**Berry Equestrian Centre
Submission
to the
NSW Department of Planning and Infrastructure

regarding the proposed
Foxground and Berry Bypass Project**

**17 December 2012
Berry Riding Club
Judy Sweeney
Secretary
Ph 4464 1143**

RELOCATED PONY CLUB
AREA (INDICATIVE ONLY)

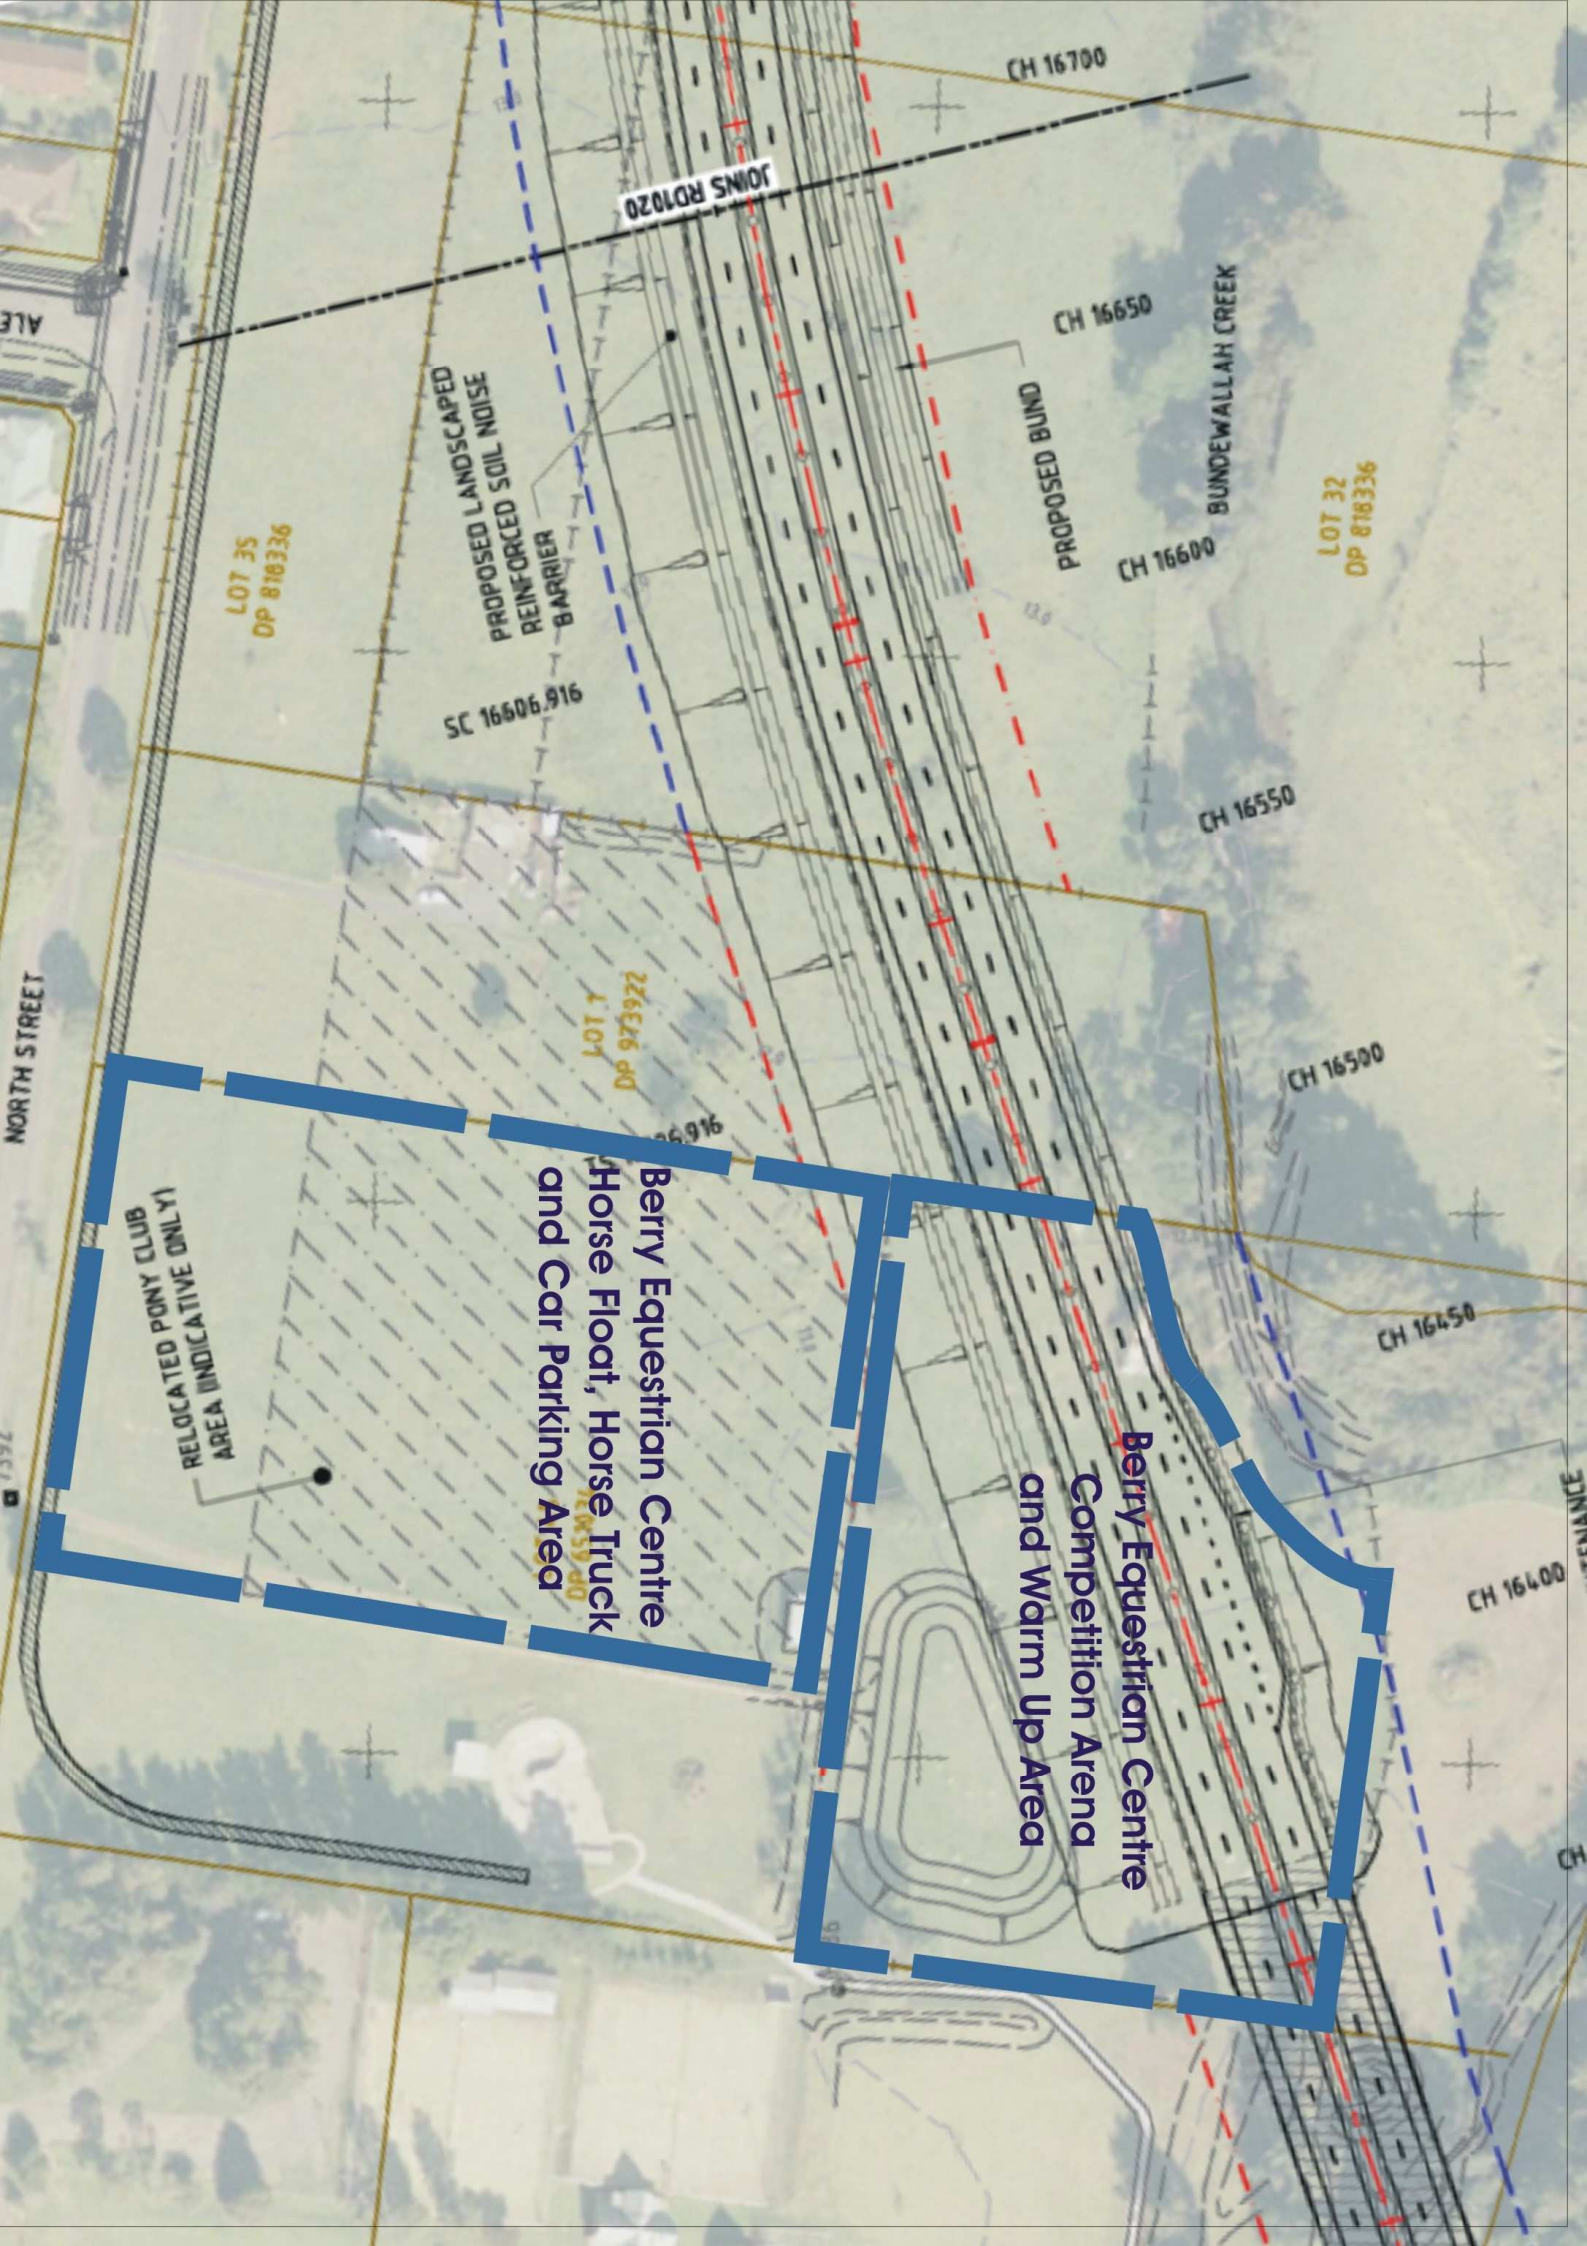
The design and loss of land of the proposed relocation of BEC to a reduced part of the existing site will detrimentally affect the riders, spectators and community as a whole.

It is in the public interest that BEC continue to provide dedicated grounds that cater to no less than the present capacity and service the community. The proposal with the reduced area and realignment of activities will restrict and likely prevent the ability of user groups to conduct equestrian events of even the current size and would certainly constrain the ability to hold any larger events or grow the club. For instance, although the Berry Public School Inter-school Equestrian Championship is organised from Berry, due to its size it has to be held at grounds some 45 minutes away which requires considerable effort transporting all of the dressage, sporting and show jumping equipment required for such an event. It is held over a 3 day long weekend and attracts nearly 200 competitors who travel from as far as the Northern beaches of Sydney, Bega in the South and Canberra in the West.

- The competition grounds are required to be rectangular /square in shape of a minimum size of 140 metres x 140 metres with a level, well drained, good riding surface in order to cater for at least 4 dressage arenas or 2 show jumping arena's;

- The parking area is required to be of a minimum area equivalent to 90 metres x 160 metres and allow for easy entry, manoeuvrability, parking and exit of horse floats and trucks. A generous amount of space between vehicles is a must. Each parking space is equivalent to an absolute minimum of 4 to 6 normal vehicle spaces due to the need for unloading/loading and tie up areas for horses. When vehicles with horses tied up next to them are located too close to one another, the risk of injury to people and other horses is increased substantially. Horses are a flight animal and are often easily spooked and break from their tie. A horse running loose in between vehicles that are closely stacked together in a parking area can pose quite a danger.

Shown below is the current layout of BEC bordered in blue, overlaid on the drawings of the proposed Bypass route. The hatched area shows the proposed relocated, realignment of the competition and parking area which is estimated to be approximately half the area currently available.

There is concern for the safety of horses, riders and the general public due to the near location of the proposed riding area to the four lane expressway, the skateway, the public cycleway/walkway and to North Street. These are incompatible land uses for the following reasons:

Horses are a flight animal, and can be spooked by noise and moving objects with disastrous effects. There will be anticipated significantly increased noise and visibility of cars and trucks travelling at 100km/hour on the bypass with horses competing nearby, often with young and inexperienced riders. Accordingly, horses, riders and spectators may be subject to an increased level of potential to injury should a horse be spooked by external activities occurring quite close to the riding arena. These are not uncommon events and BRC can provide extensive examples of horses being spooked and causing serious injury. Currently the competition arena is located in a very quiet area away from other distractions.

The EA does not consider the impact of noise or traffic on horses in competition or training and BRC is unable to determine the exact extent of these impacts. However, the BRC is aware that for sites such as the Sydney International Equestrian Centre, there are 5 metre noise barriers along the M7 even though the competition areas are around 200m from the boundary and are located at significantly reduced topographic levels compared to the road. BRC accepts that it is unlikely to be desirable to install 5 metre noise barriers along a long section of the Bypass to protect against noise and the tops of passing trucks.

Access to the grounds is likely to be across a public shared cycleway/pathway. The safety of children riding skateboards, bicycles etc on adjacent land are at risk as horse trucks and floats cross the pathway access. Horse floats and trucks also require an indented driveway of at least 15 metres to allow vehicles to park safely off the roadway whilst gates to the grounds are opened and closed. Vehicles come and go continuously throughout the days when competitions are held as people know when their riding times are and arrive to suit that time. They then leave after they have competed. Competition days are usually on weekends, when the cycleway/pathway usage is also likely to be at its greatest.

- An Options Paper be prepared with input from BRC that examines not only modifications to the current BEC site, but also examines and proposes an alternate site to which the BEC could be relocated.
- RMS commit to ensuring that equestrian facilities will be relocated / re-established to a level acceptable to the BRC.
- Furthermore the BRC request that should the parties disagree on relocation or the provision of new / relocated equestrian facilities, that the Director General of the Department and Planning and Infrastructure facilitate a resolution.
